PINS Reference TR050006 Northampton Gateway RFI

IP REF. SP074 - South Northamptonshire Council

South Northamptonshire Council - Comments on Applicant’s Responses to ExQ1 – Applicant document - 8.2

**FIGURE 4.1**

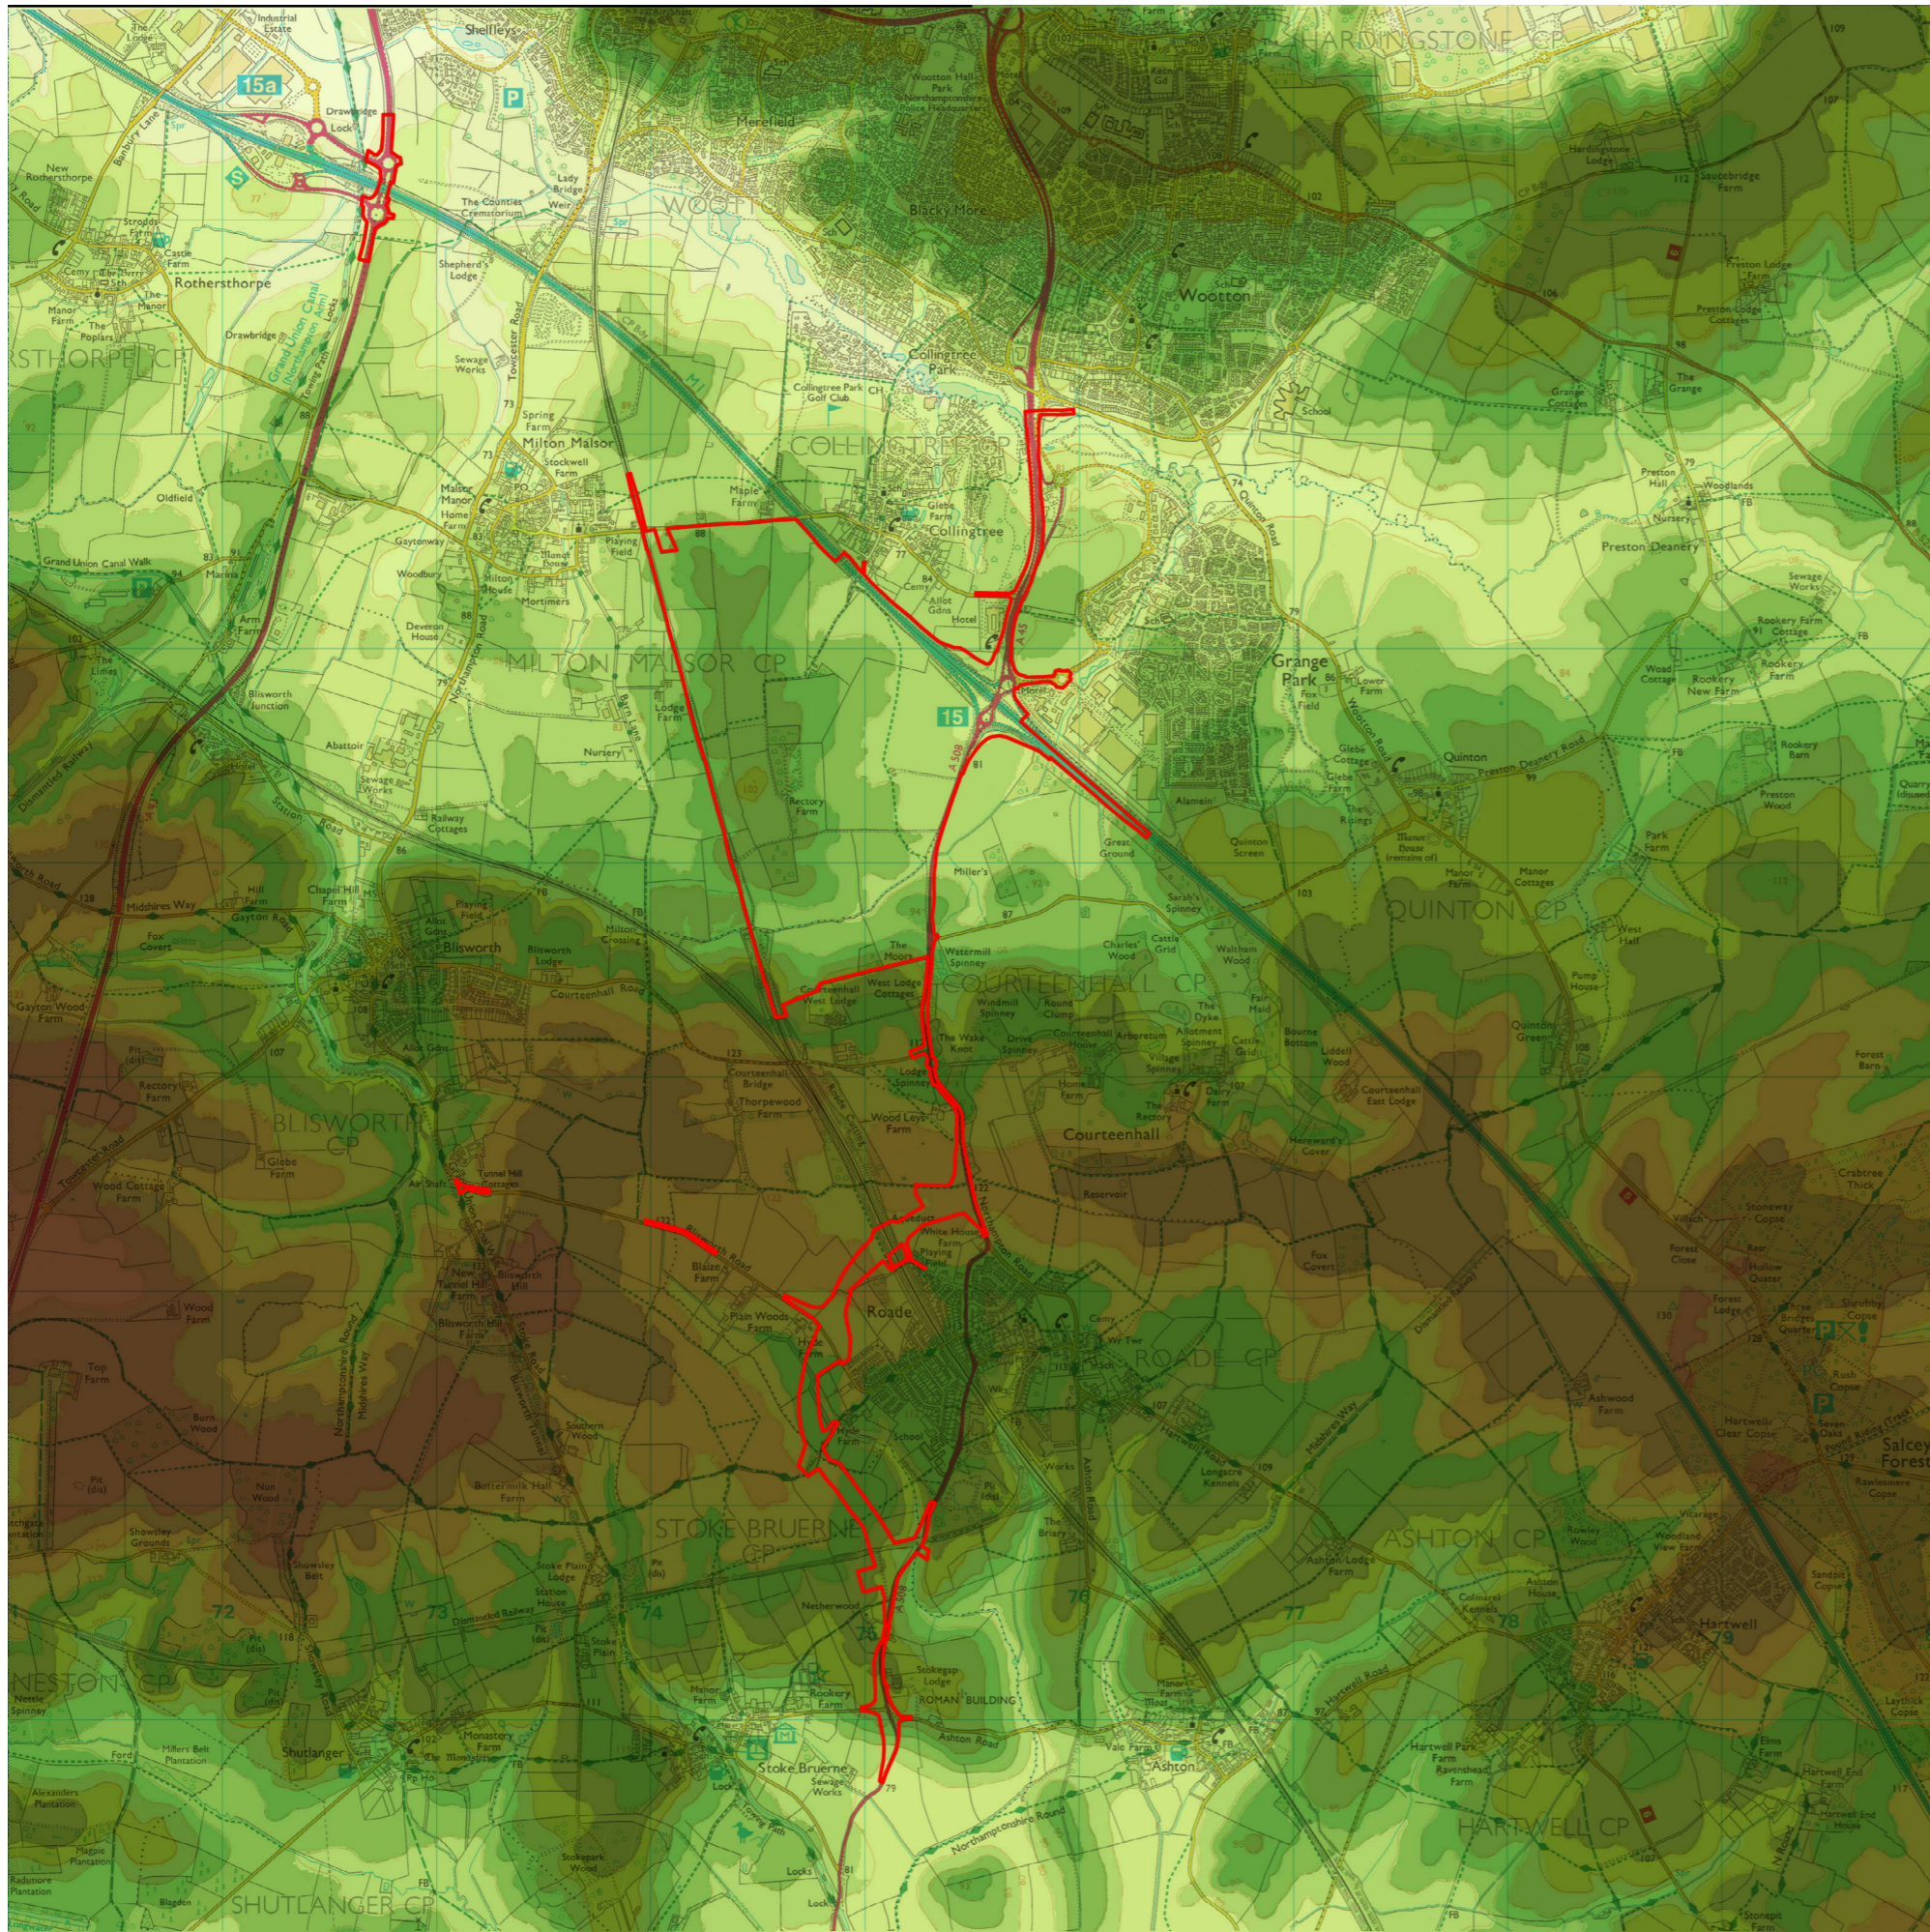
ExA Q1	Question	Applicant Response	SNC comment
1.0.9	<p>ES Chapter 4 (Landscape and Visual Impact) Figure 4.1 [APP-085] shows a substantial portion of the main site of the Proposed Development falling within an ‘Area of Important Local Gap’ to which saved Policy EV8 of the South Northamptonshire Local Plan applies. This policy seeks to prevent development that would significantly intrude into this gap. Please comment on the significance of the apparent conflict with this policy.</p>	<p>The 1997 South Northamptonshire Local Plan included a policy (EV8) which identified a local important ‘gap’ adjacent to the M1 where development was actively discouraged. This was on the basis that the land represents ‘<i>attractive countryside</i>’ but primarily to prevent coalescence with nearby villages. The 1997 Local Plan was prepared in the context of the former Regional Planning Guidance, and County Structure Plan - it clearly pre-dates the NPPF, and (by in excess of 15 years), the adopted Core Strategy of 2014 which was prepared in the context of the NPPF, and with regard to an updated evidence base regarding landscape value. While ‘saved’ (in 2007), policy EV8 is clearly out of date, and the policy approach of seeking to identify the area of landscape south/west of the M1 for preservation has not been carried forward or updated through subsequent Local Planning policies since 1997. Parts of ‘local gaps’ are now included for development as part of SUEs in the Northampton Related Development Area which extends into South Northamptonshire. EV8 is therefore considered contrary to strategic policies of</p>	<p>Annex1 to the NPPF 2018, makes clear existing policies should not be considered to be “out of date” simply because they pre-date the current version of the NPPF. Paragraph 213 states “However, existing policies should not be considered out of date simply because they were adopted or made prior to the publication of this Framework. Due weight should be given to them, according to their degree of consistency with this Framework (the closer the policies in the plan to the policies in the Framework, the greater the weight that may be given)”.</p> <p>The reference within the applicant’s response to saved Policy EV8 being out of date because it predates the NNPF is erroneous.</p> <p>The emerging SNC Local Plan Part 2 does not include a specific policy to identify important local gaps, however the principles enshrined within saved policy EV8 are carried forward. Policy SS2, a generic policy, seeks to ensure that planning permission is granted for sustainable well designed development that will respect the context in which it will be set. This policy continues to recognise the importance of maintaining</p>

ExA Q1		Question	Applicant Response	SNC comment
			<p>the now adopted Joint Core Strategy which identifies development '<i>in and adjoining</i>' the principal urban area of Northampton as the key location for major growth, and which provides criteria for the assessment of landscape and other effects, without reference to Policy EV8 or any "local important gap".</p>	<p>the individual identity of towns and villages and the significance of the open countryside between settlements to this.</p> <p>Policy SS2 states, inter alia, 1. " Planning permission will be granted where proposed development : a. Maintains the individual identity of towns and villages and does not contribute to any significant reduction of open countryside between settlements or their distinct parts;"</p> <p>Neither saved Policy EV8 or emerging Policy SS2 is inherently inconsistent with, or is 'contrary to', the objective within the WNJCS to promote development in and adjoining the urban area of Northampton. These policies identify the importance assigned to the relationship between new development and existing settlements and provide principles to guide the consideration of this to ensure these will relate well to each other and to maintain the identity and character of existing settlement. The latter are intrinsic characteristics of the pattern of dispersed settlements of South Northamptonshire.</p>
